Our Ref: A/147/18/HH
Your Ref:

Town & Country Planning Act 1990 (as amended)
Town & country Planning (Development Management Procedure) (England) Order 2015
Application for Planning Permission for Works or Extension to a Dwelling

Development Proposed single storey rear extension
Location 79 West Drive Angmering

DRAWING No.
Drawing 2
Existing Elevations

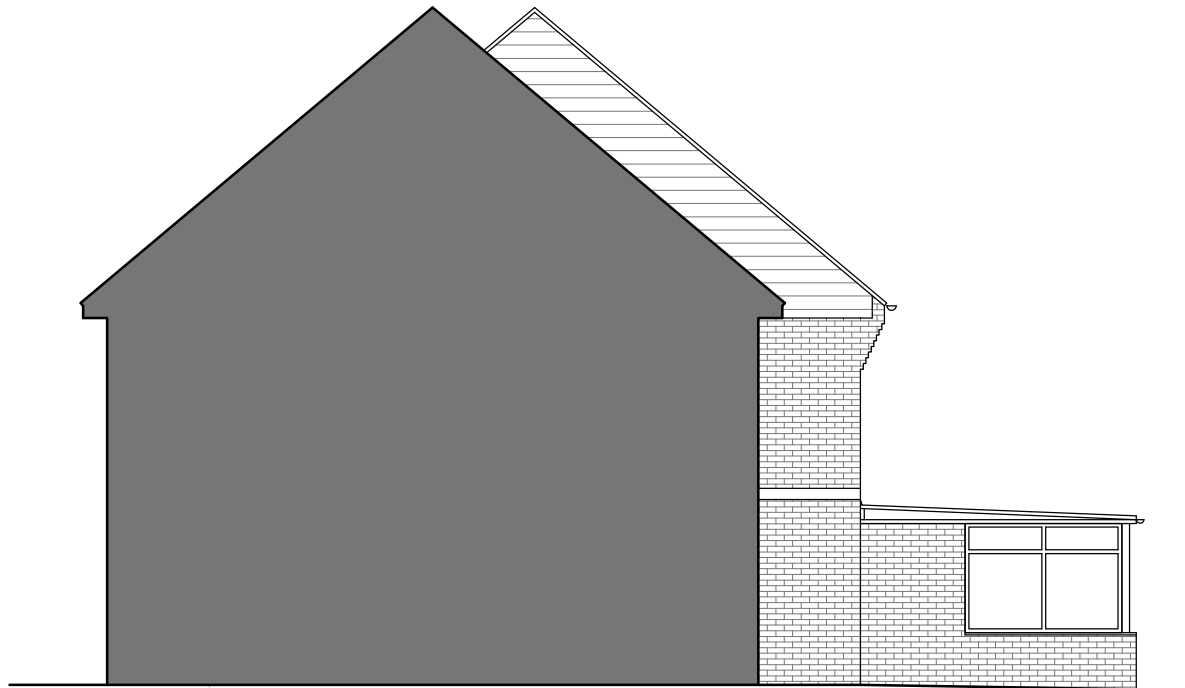
Other Side Elevation Required: Please provide the other side elevation as the proposal extends past the existing building line of the neighbouring property. Please submit this at a stated standard metric scale such as 1:50 to 1:100 with a scale bar or dimensions annotated to allow the confirmation of the scale.
